Planning application no: 2021/94552

Land at, Barnsley Road, Denby Dale, Huddersfield HD8 8TS.

Erection of 53 dwellings and associated works

Comments for inclusion in the public consultation relating to the above planning application.

Appendix 1: Notes on Drainage Strategy

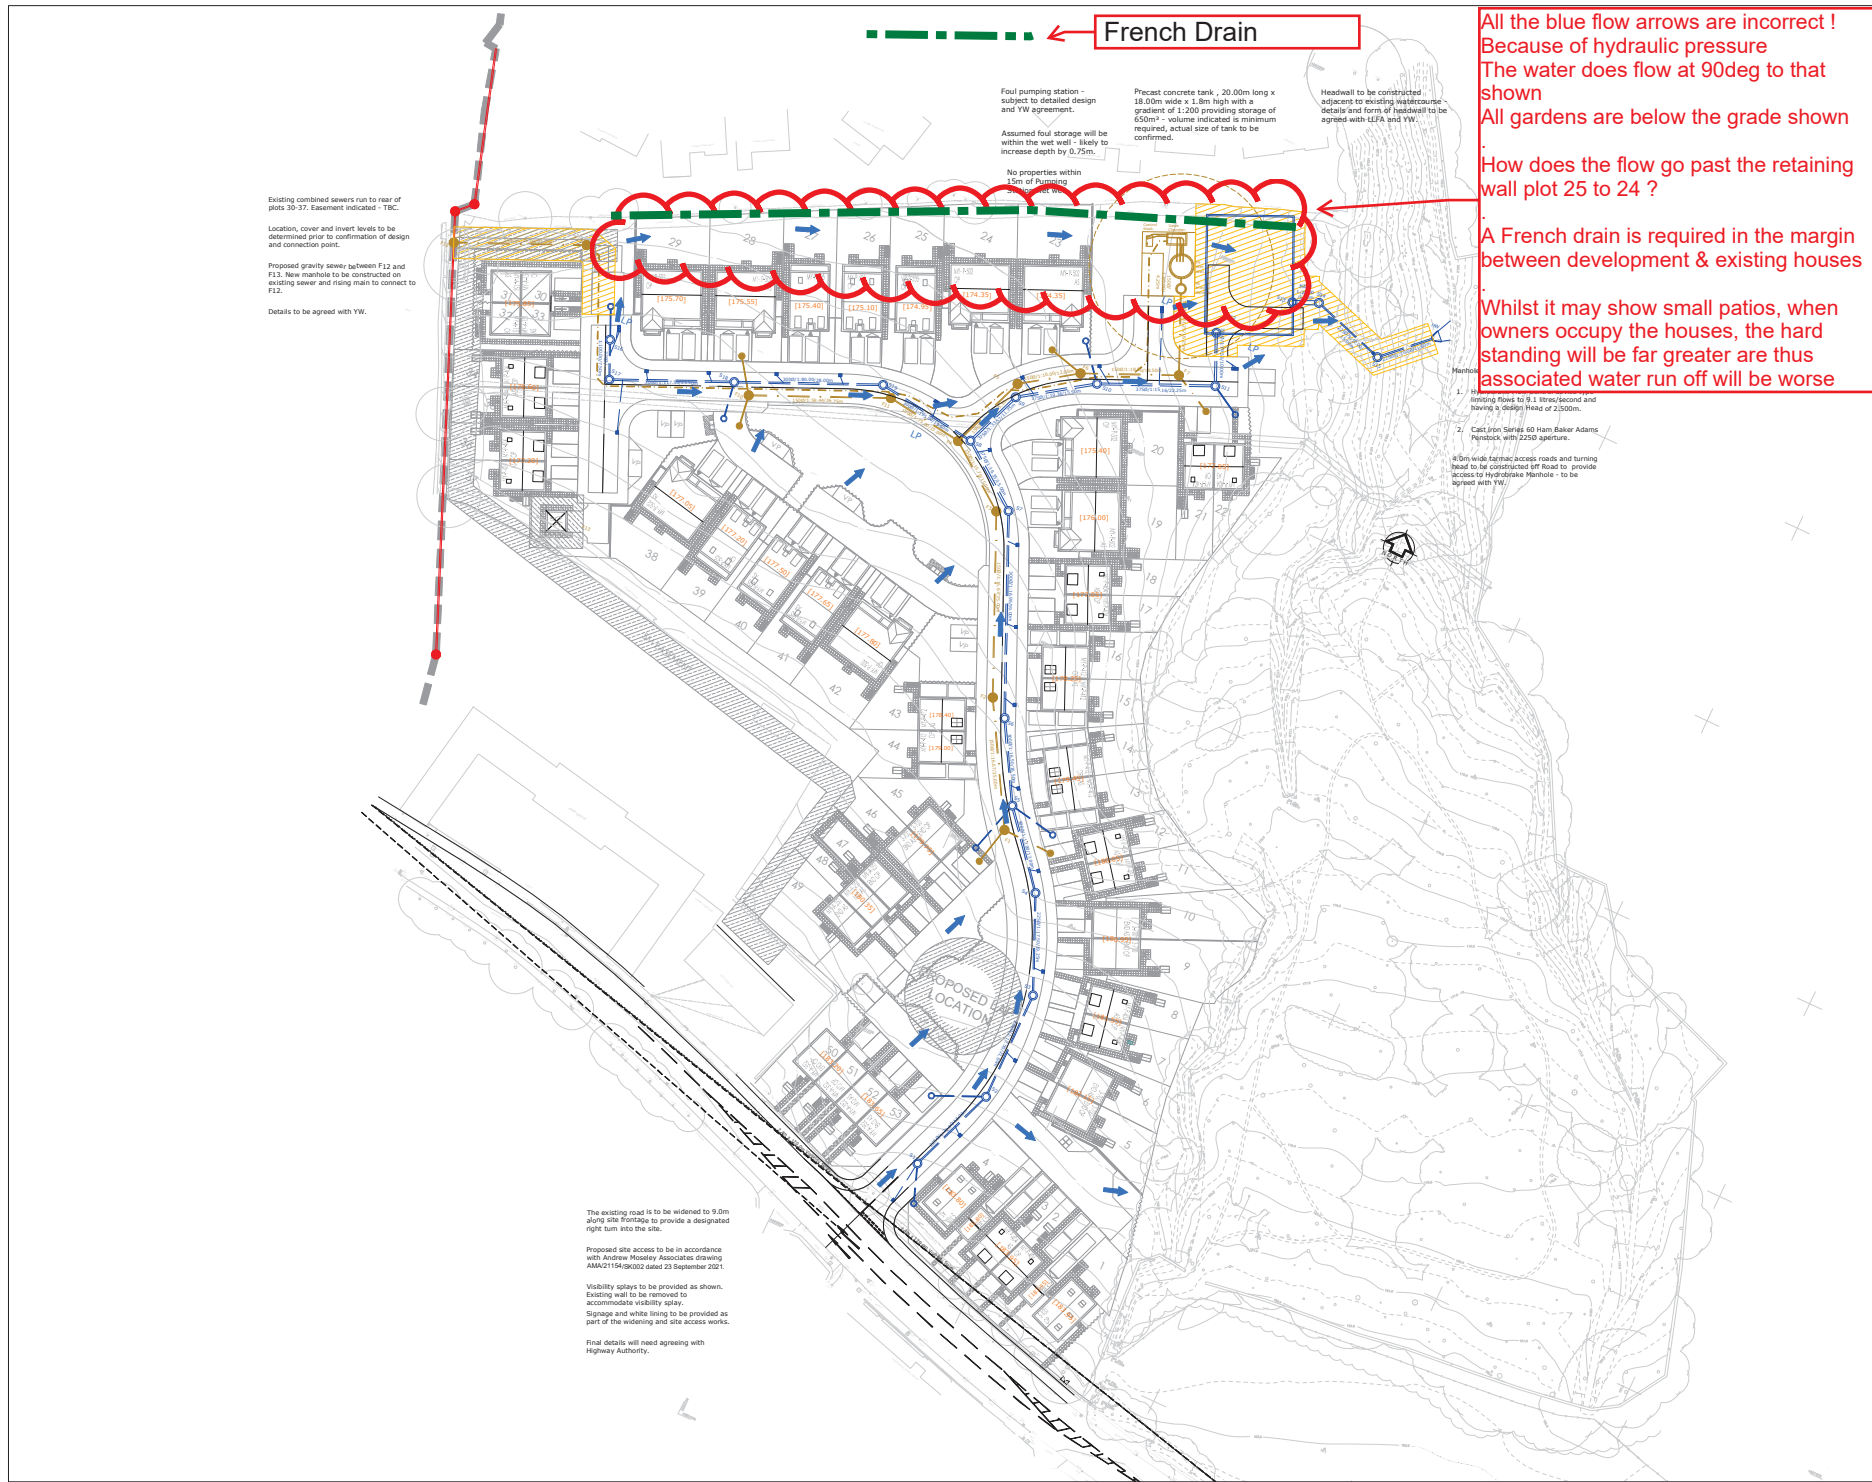
- c) The Drainage Strategy Plan (ref 5212-C-D-9-03, page 31 of Geo Structures Civils Flood Risk Assessment & Surface Water Management Strategy id908369) shows surface water running west to east along the northern boundary – see Appendix 1. For this to be effective the datum of the houses needs to be at 172.00

Given that the rear gardens of the proposed housing nearest this boundary slope markedly toward the northern boundary (more so than currently), it is impossible for surface drainage water to run in an easterly direction toward Tanner Wood as suggested on this plan.

Furthermore, boundary walls between the gardens of the new properties run north to south down toward the northern boundary. Hence, surface run off from this area will be further forced directly into the gardens of the existing properties north of this boundary.

A French drain running along the northern boundary is therefore a minimum requirement. (See Appendix 1) and the level of the new houses along the northern boundary should be lowered to reduce run off (See also section 4a below).

5. The drainage plan along the northern boundary is redrafted to show realistic flow directions in line with the topography of this area, i.e., into the gardens of neighbouring properties, and to include appropriate mitigation.

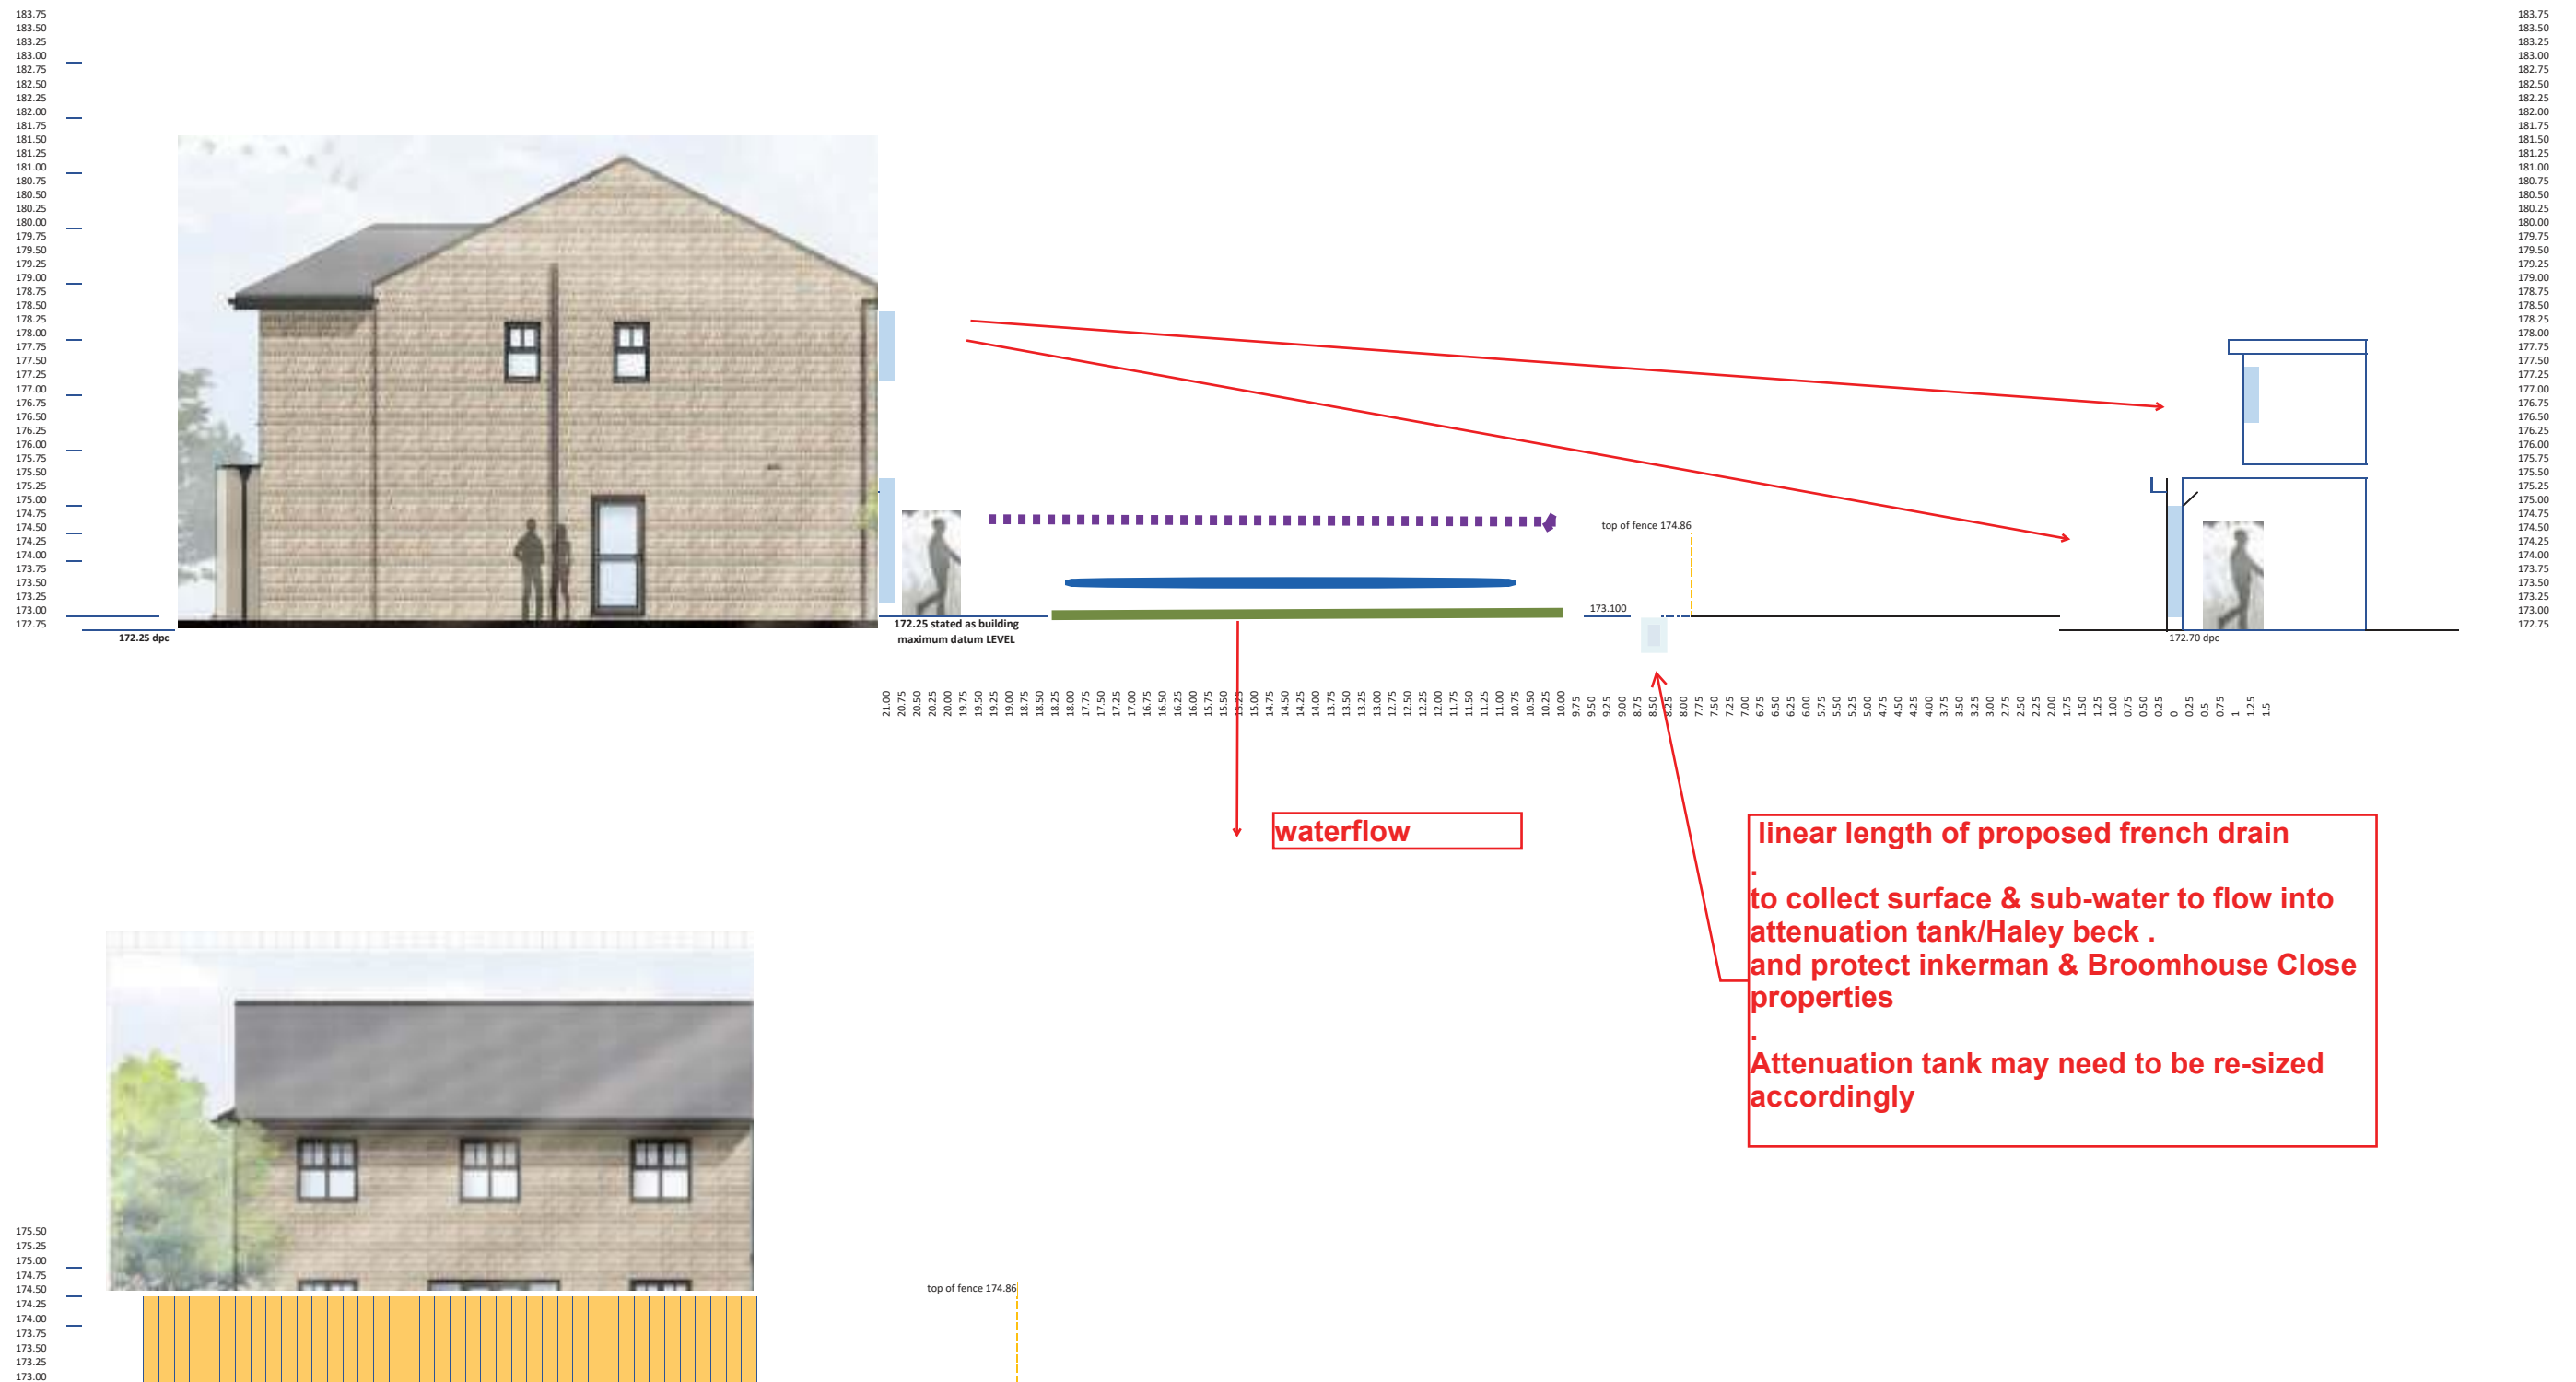
- b) Given the significant loading on the foul water pump station (See Drainage Strategy Plan: ref 5212-C-D-9-03, page 31 of Geo Structures Civils Flood Risk Assessment & Surface Water Management Strategy id908369), what are the contingences should power to the pump fail? It should be noted that power cuts in Denby Dale are not uncommon, and these power cuts have been longer than 4 hours, which is in the design brief by the consultant. Note that Yorkshire Water's advice is only the minimum, not the most appropriate level of power downtime

- c) The Drainage Strategy Plan (ref 5212-C-D-9-03, page 31 of Geo Structures Civils Flood Risk Assessment & Surface Water Management Strategy id908369) also shows that surface water from the site runs from the attenuation tank into Haley Well Beck in Tanner Wood. This beck runs into an underground culvert under two properties on Dearnside Road to the north of the site that have previously experienced flooding after the culvert was overwhelmed. We have

The civils plan shows rainwater pipes (RWP's) at low points with no discharge point connection detail indicated. Unless suitable connection and discharge points are made this means a direct discharge into number 8 Broomhouse Close from several building plots.

## BARNSELEY ROAD, DENBY DALE - CONCEPT MASTERPLAN

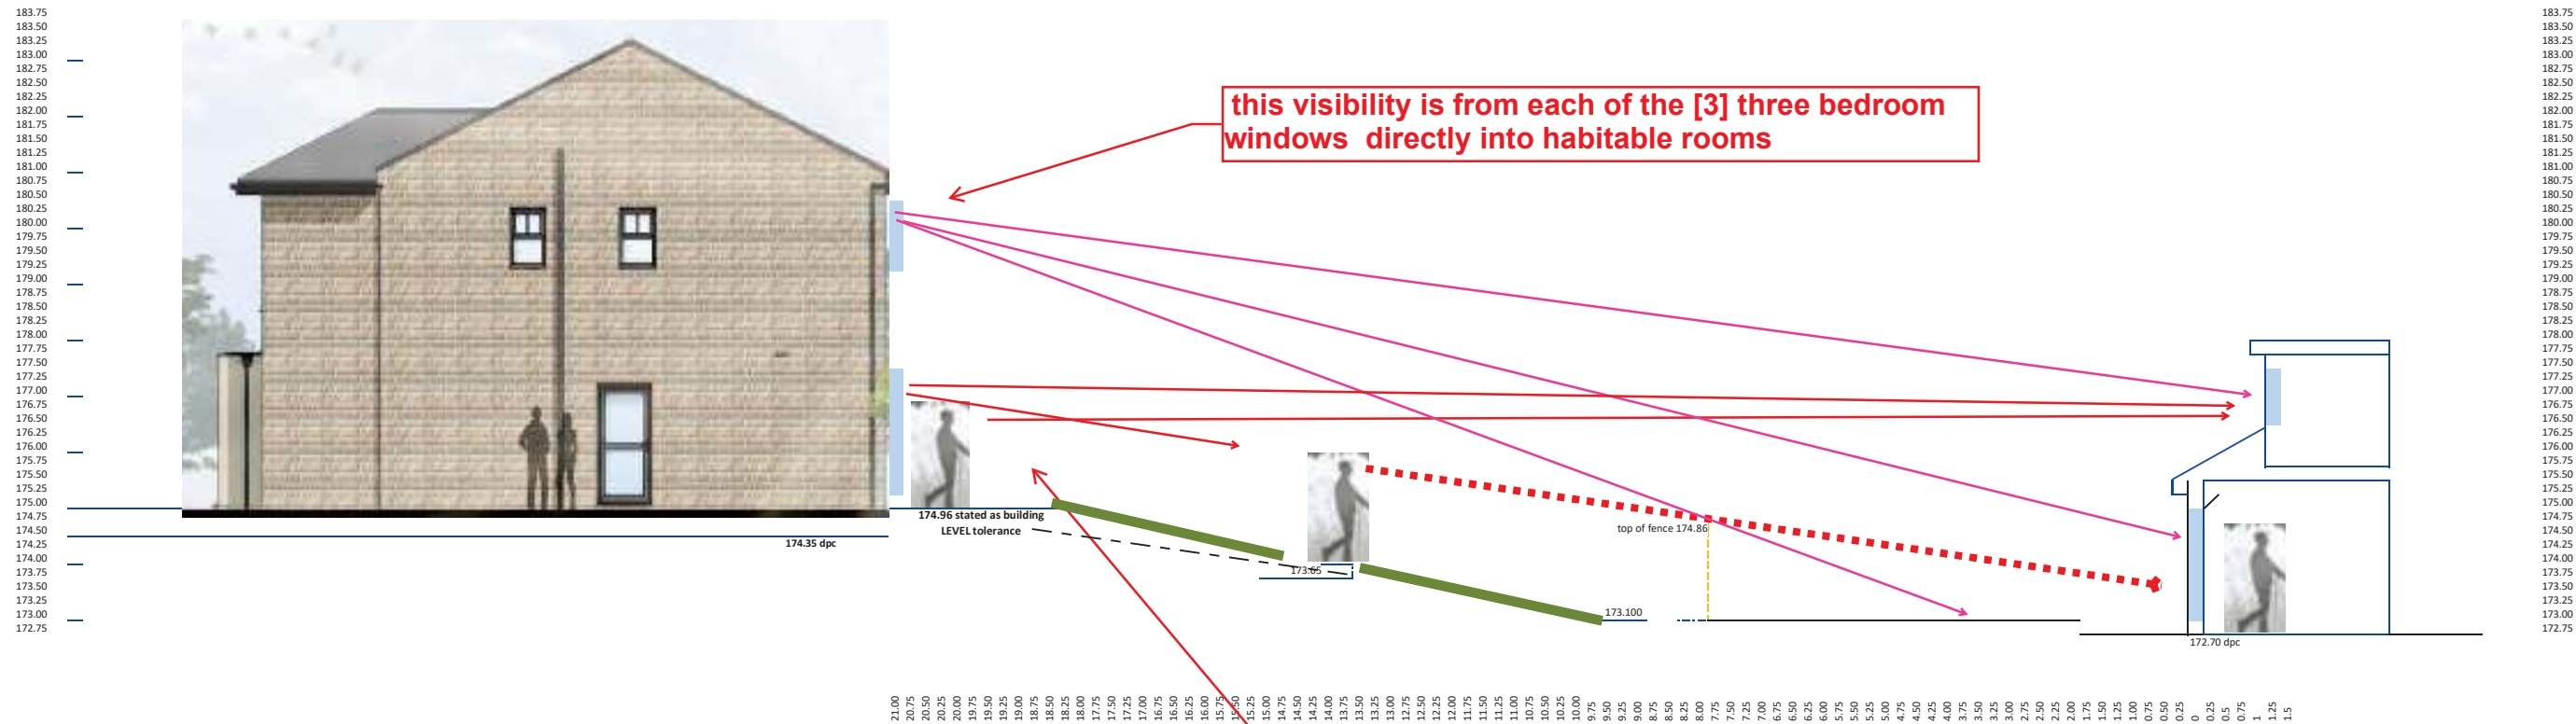
We would also ask why the balancing pond shown on the northern boundary of the original concept masterplan (see Appendix 3) has now been replaced by an attenuation tank? In the Statement of Community involvement, Pegasus Group state that this *'takes into account feedback from the Council's Officers received during the pre-application process'* but in a conversation with the Kirklees Planning Case Officer on the 9th, February 2022 he was unaware of any such feedback. A written question to establish the nature of this feedback to the Planning Office remains unanswered.
